# ENG-PUDSP21005-R3-PUDSP.pdf Markup Summary

**Subject:** Callout  
**Page Index:** 1  
**Date:** 4/15/2022 3:10:03 PM  
**Author:** Ryan Howser  
**Color:** ■  
**Layer:**  
**Space:**  
**Page Label:** [1] WB PUDSP 3.10.22-Cover

**1**

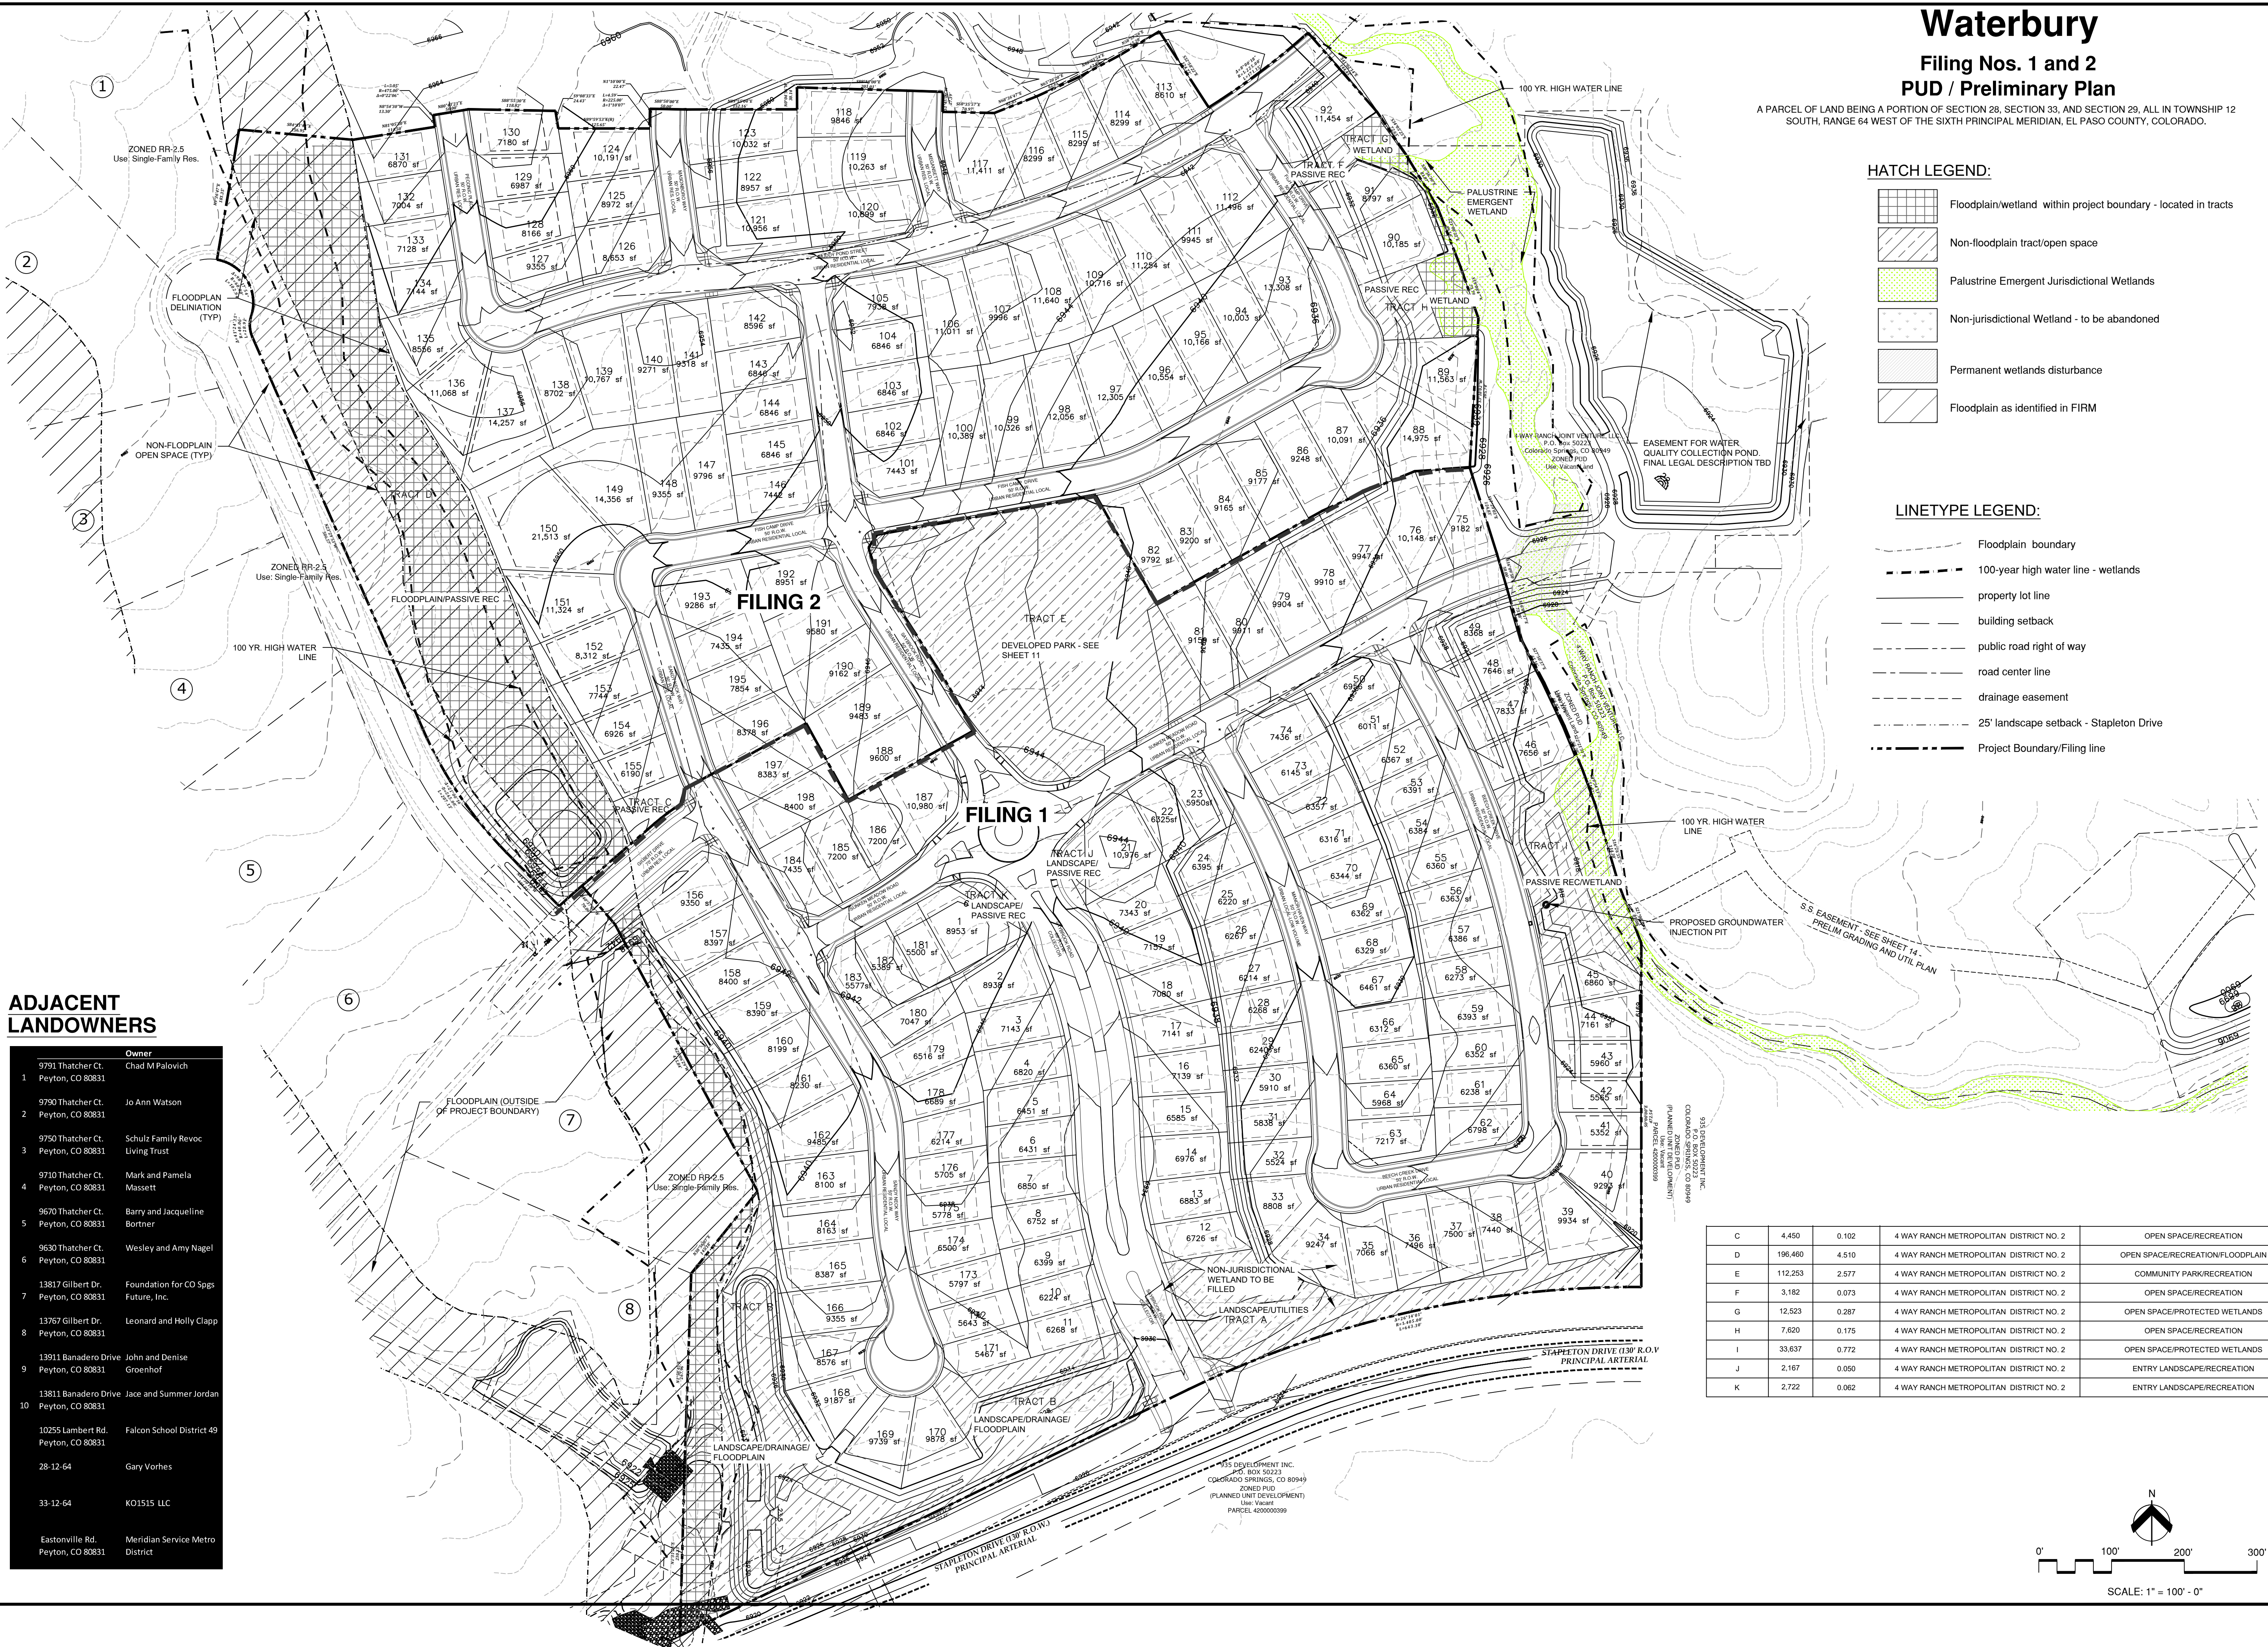
This is in conflict/redundant with the easement note in the table on the right side of this page. Please delete this note.

This doesn't explain much. According to this, the ONLY allowed use is single-family residential lots. No parks, community facilities, etc. No accessory uses have been identified. Either reference a zoning district or list all of the uses. Original PUD for waterbury listed the uses.

All of the lots are less than 2.5 acres? Please revise for clarity.

The calculations here are different than those that appear on the LOI. Please revise where appropriate.

Sidewalks cannot encroach into ROW triangle.

This note is also provided to the right and can be deleted.

Optional Type C (Not Type 2)

SHEET TITLE:  
**TRACTS  
PLAN**

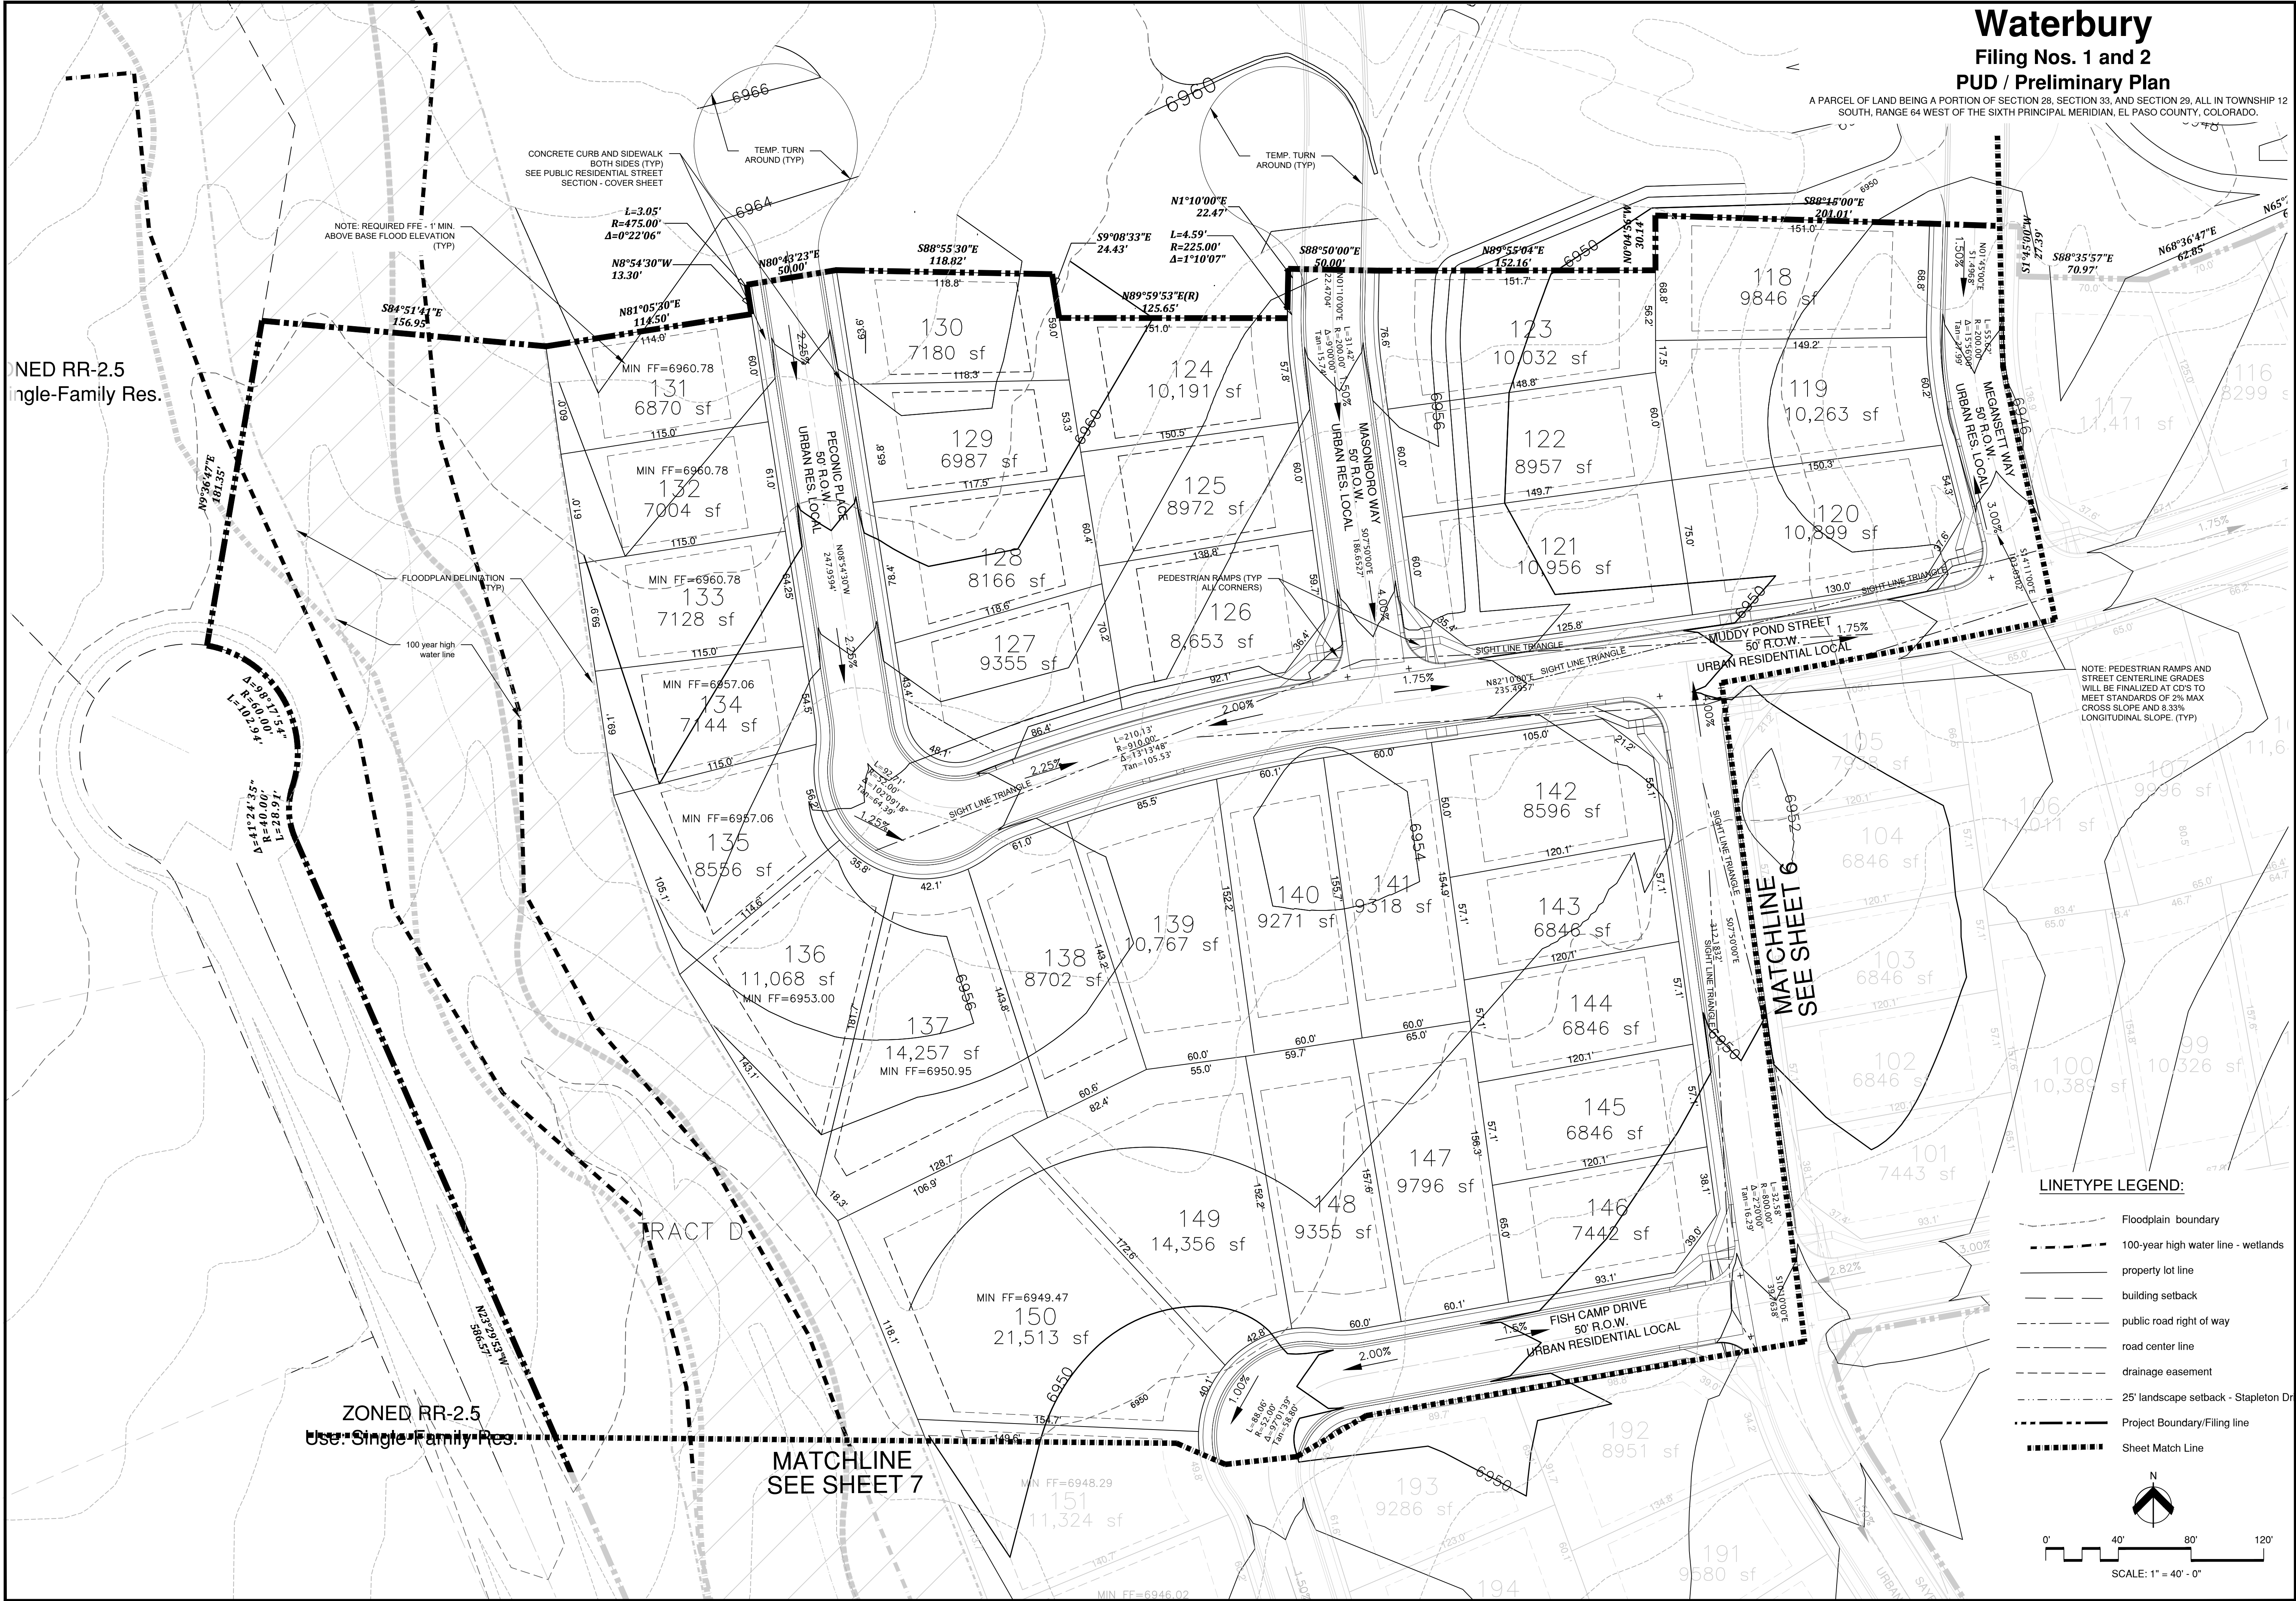
Show delineation between 2 drainage easements called out

please turn off the text box outlines

SHEET TITLE:  
**NORTHWEST AREA DEVELOPMENT PLAN**

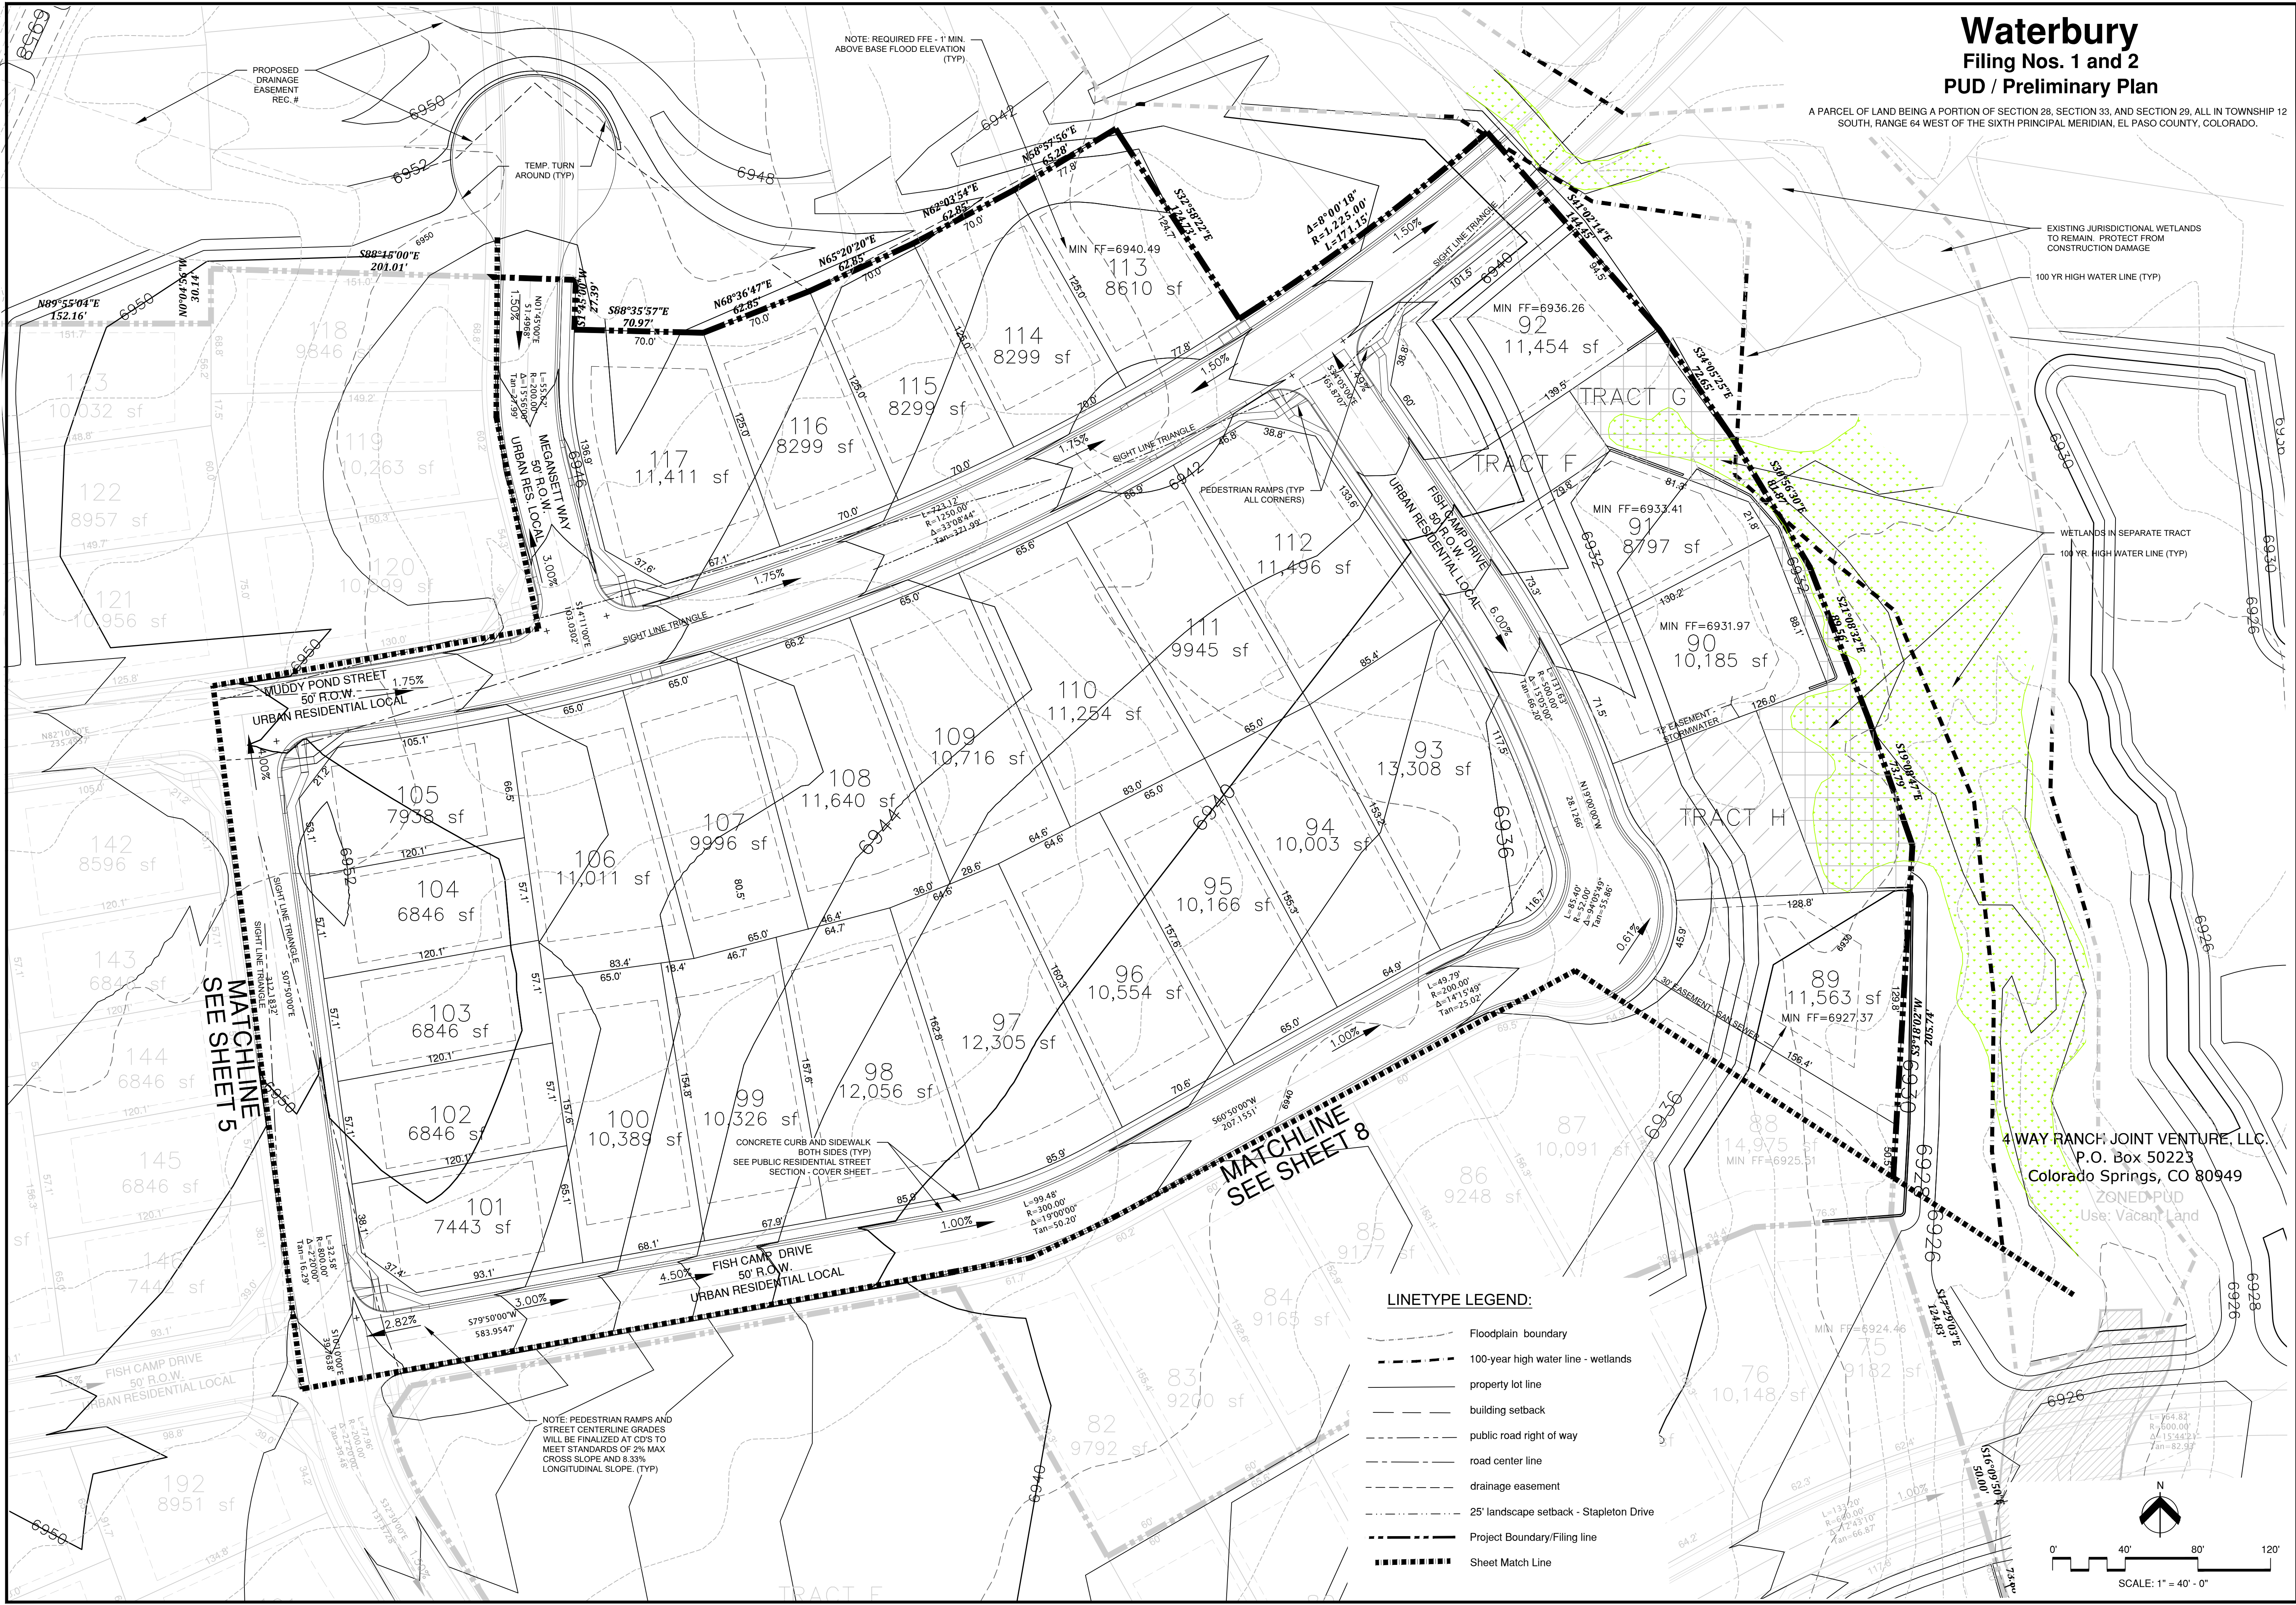
Label sight line triangle line

These grades and others highlighted on this sheet are higher than allowed for ADA crossings. Ensure that the pedestrian crossing cross-slopes will meet criteria.
